City of Albuquerque Stormwater Construction Site Inspection Report

Project Name:	3050 Painted Rock		
Location:	3050 Painted Rock		
Site Contact Name & Agency	Robert Schultis - All-Rite Const.	ESC File No.	G10E029D
		NPDES Id. No.	NMLEWA301
Inspection Date:		Start/End Time:	
CoA Stormwater Inspector:	Timothy Sims		
Construction Phase:	grading		
Type of Inspection:	<input checked="" type="checkbox"/> Regular	<input type="checkbox"/> Storm Event	<input type="checkbox"/> Post Storm Event >0.25" <input type="checkbox"/> 311/Complaint <input type="checkbox"/> Follow Up

Concrete Washout Area

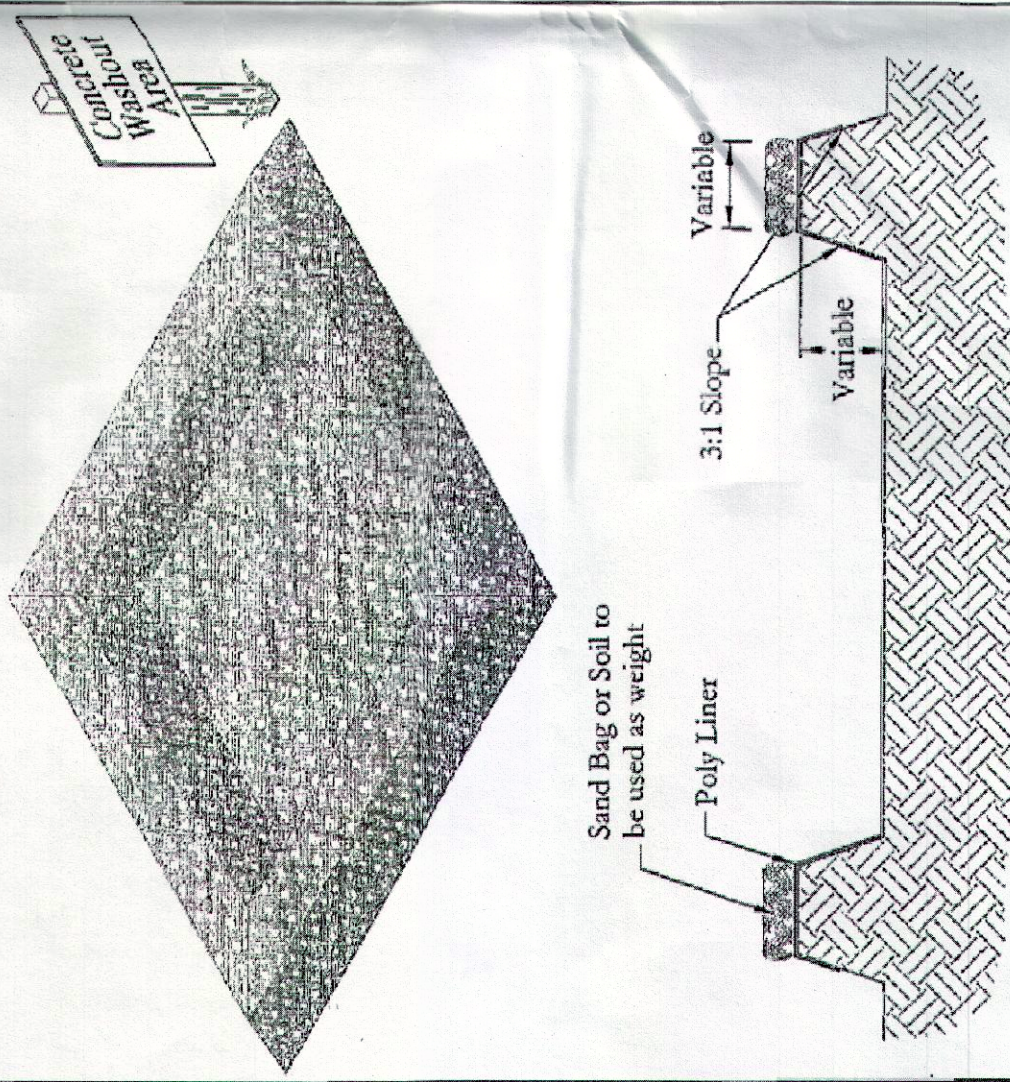
Item Number	Deficiency/ Corrective Action		
1	Please provide Stormwater Quality Approval and post in view to the public at site.		
2	Dirt Ramp onto BoB McCannon Parkway requires removal and an acceptable access ramp is required.		
3	Concrete washout not in acceptable container.		
4	Please provide latest SWPPP self-inspection report.		
2.1	Discharge off site? (Y/N)	No	
4	Self Inspection Reports	requested	Latest report Date: not on file
